September 4, 2024

December 12, 2024

Re: Freddy's at 4315 Wyoming Blvd NE  
Erosion and Sediment Control Plan  
Engineer's Stamp Date: missing (G19E004G)

Based on the information in your submittal, received on 5/23/24 and 12/12/24, the above-referenced ESC Plan can't be approved until the following comments are addressed. Highlighting and red comments were added on the second application. Comment#2 is the only comment addressed in the 2<sup>nd</sup> application.

ESC-1

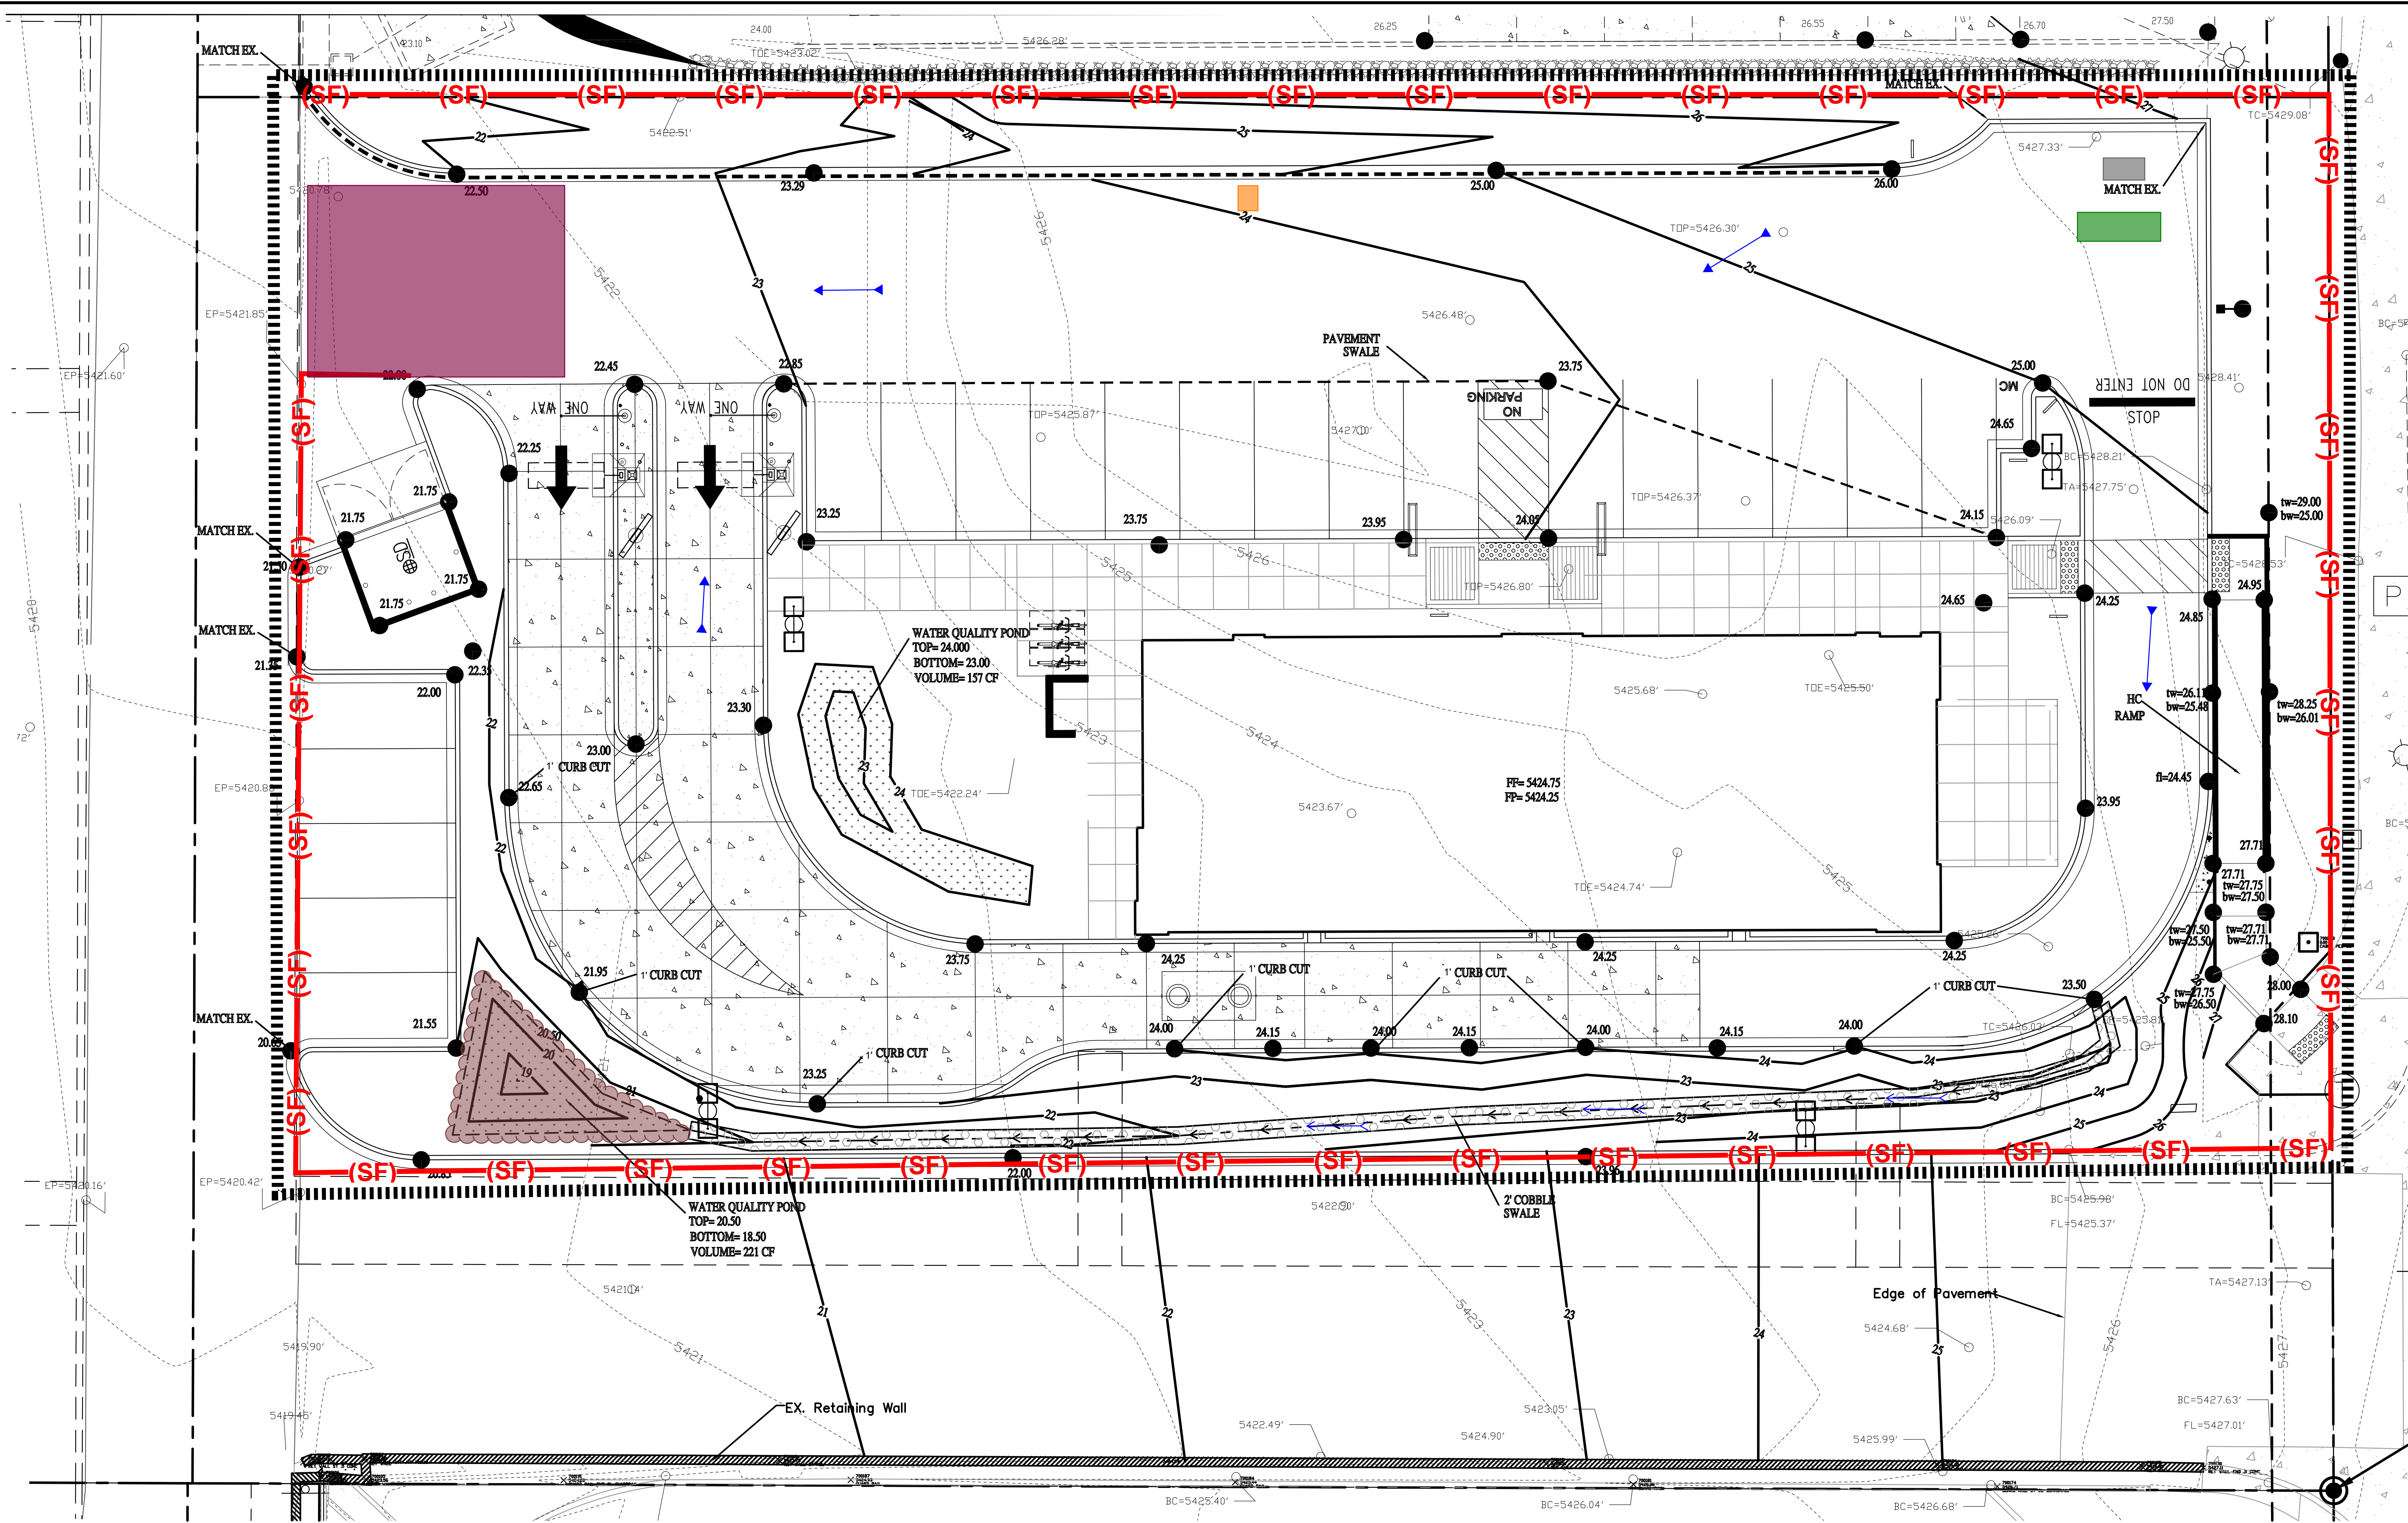
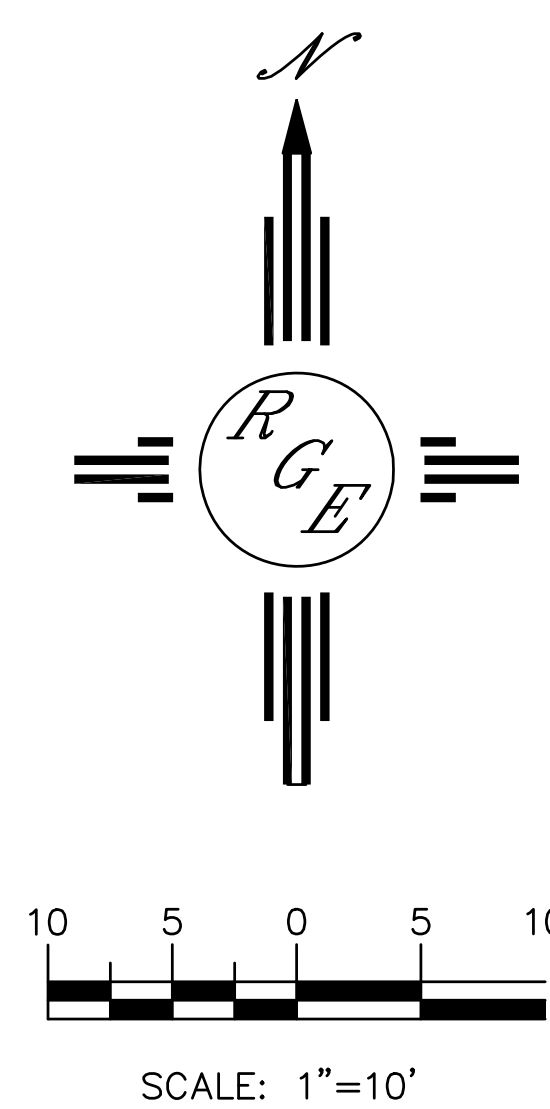
3. The ESC Plan is blurry and not legible. The sheet size is too small (smaller than 8.5"x11"), and the plan is not drawn to scale. The ESC Plan must be on 22" x 34" sheets per the city drafting standards in DPM Part 4-2(B). Each ESC Plan sheet should have an ESC Plan title block that identifies the sheet number and the total number of sheets in the ESC Plan, for example, "Sheet 1 of 5." Loose, unstamped sheets are not allowed.

4. A legend showing the limits of disturbance and BMPs is missing and is required by the drafting standards and must be shown on the ESC Plan.
5. The Limits of Land-Disturbing Activities are missing from the ESC Plan. You must accurately identify the location of limits of disturbance on the ESC Plan. Be sure to include any offsite construction support activities in the limits.

6. The Construction Exit (CE) isn't allowed at the handicap ramp on Wyoming Blvd. as currently shown on the ESC Plan. A more likely location is at the end of the existing paved driveway onto Wyoming Blvd. Relocate the CE on the ESC Plan and provide dimensions and construction specifications. Make

sure that traffic can't bypass the CE. The location, dimensions, and construction specifications are still missing.

9. Construction details and specifications are missing from the ESC Plan for most of the stormwater controls, including but not limited to the construction exit, diversion berms, sediment traps, washout, and waste containers.

11. The ESC Plan isn't stamped by a professional as required by CGP 9.6.1.c.iii. Update the engineer's stamp date each time the ESC Plan is changed. Robert Fierro PE is identified in the SWPPP as the professional in charge of the SWPPP preparation, but his stamp, signature, and date are missing from all ESC sheets.

12. The Silt Fence (SF) locations are inaccurate, encroaching into the existing driveways on the north and west sides, and SF isn't needed along the existing wall on the south side of the site.
